Maritime &
Coastguard
Agency

Our ref: Thanet Extension Offshore
Windfarm Project (EN010084)

5 February 2019

The MCA wish to provide further responses (for deadline 2) to the information provided at deadline 1 as follows:

Figure 1: Project Site Showing Reduced Red Line Boundary (RLB).

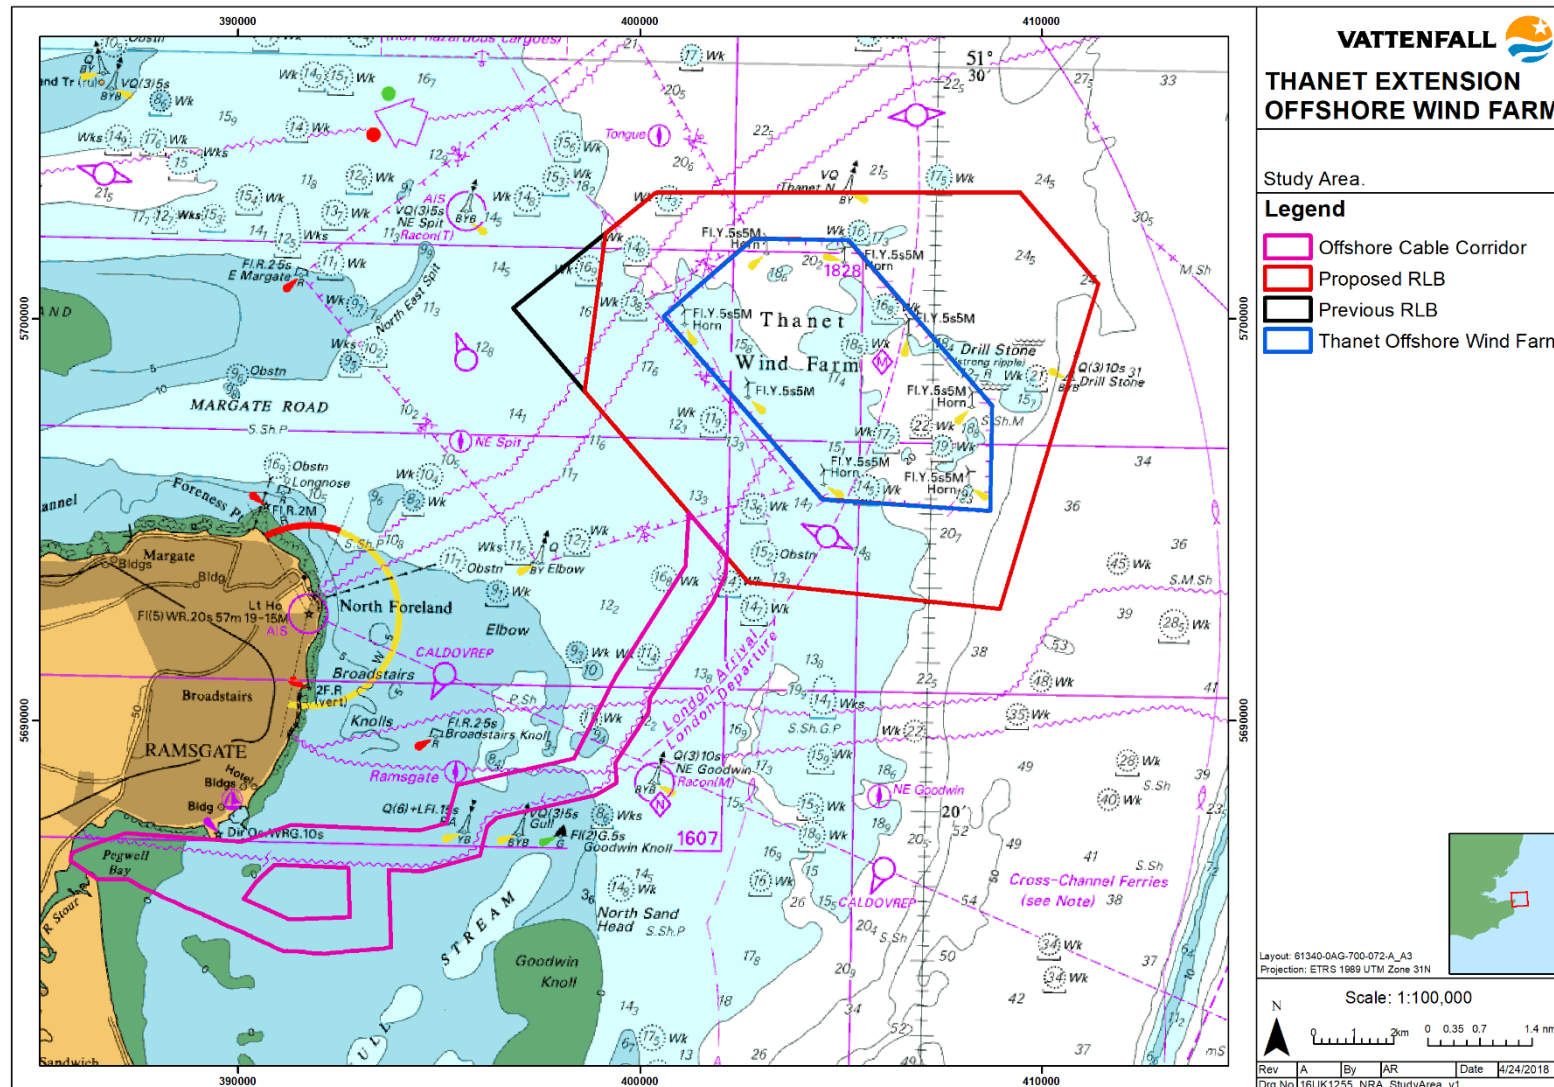
It is MCA's view that the list of concerns raised in the variety of Representations made by key navigation stakeholders are justification for the applicant to make changes to the current redline boundary on the western extent, in line with MCA's response to the Sectoral Plan submitted for deadline 1. The onus should remain on the applicant to listen to significant concerns/feedback provided by key stakeholders and work to address those concerns. It is our opinion that further mitigation is likely to be highly reliant on third parties, and that the consideration of further reducing the redline boundary on the western extent has not yet been demonstrated by applicant.

The MCA remains concerned regarding the proposed 500m Safety Zone during construction, major maintenance and decommissioning of the development. This will result in a 450m restriction outside of the redline boundary which will impact traffic between the extension and the Kent Coastline.
